15 August 2017

Canoe Bay Retirement Community
 51 Cortleigh Drive
 Ottawa, ON K2J 3Z8

**Re: 3071 Riverside Drive – Canoe Bay Development
 Transportation Impact Study – Addendum #1**

1 SITE PLAN
SP-1
SCALE = 1 : 500

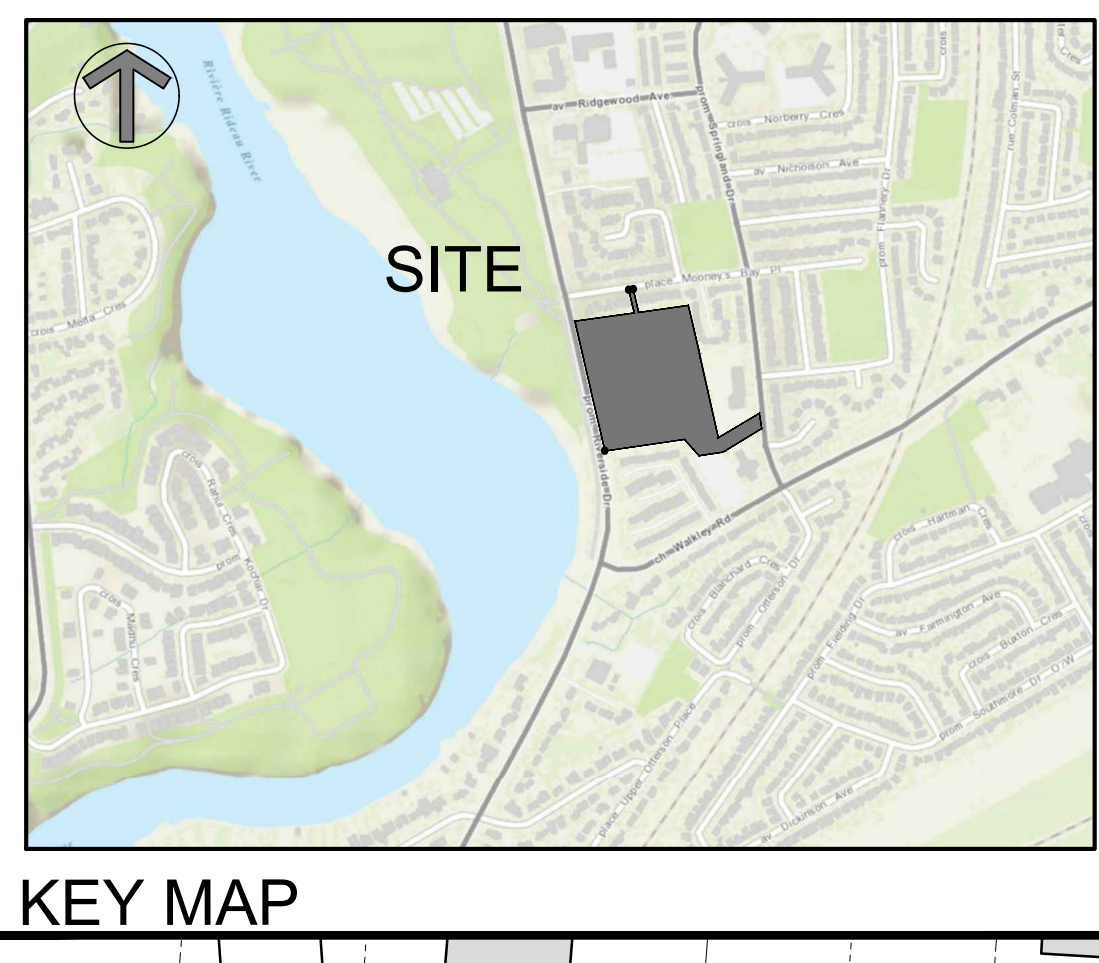
This Addendum to the original Community Transportation Study/Transportation Impact Study (CTS/TIS) has been prepared to identify the transportation-related changes to the Site Plan and address any impacts these changes will have on the overall results of the original study. The revised Site Plan is attached and includes the following transportation-related changes:

- Removal of the right-in/right-out driveway connection to Riverside Drive which provides direct access to underground parking garage;
- Slight decrease in residential units from 627 to 617 units;
- Slight increase in parking from 434 to 460 spaces;
- Relocation of the day-care facility from Springland Drive to ground floor of the northwest building; and
- Increase parking lot size on Springland Drive from 11 spaces to 25 spaces (staff parking).

The removal of the right-in/right-out vehicle access to the underground parking lot will increase vehicle traffic at the proposed signalized access and the right-in/right-out driveway connection to Riverside Drive at the north end of the site. In addition, it will likely reduce the number of U-turns at the proposed signalized access (Riverside/Site). The revised trip distribution is illustrated in Figure 1. Based on this redistribution of vehicle traffic, the resulting signalized access to the site is projected to operate acceptably, as shown in Table 1.
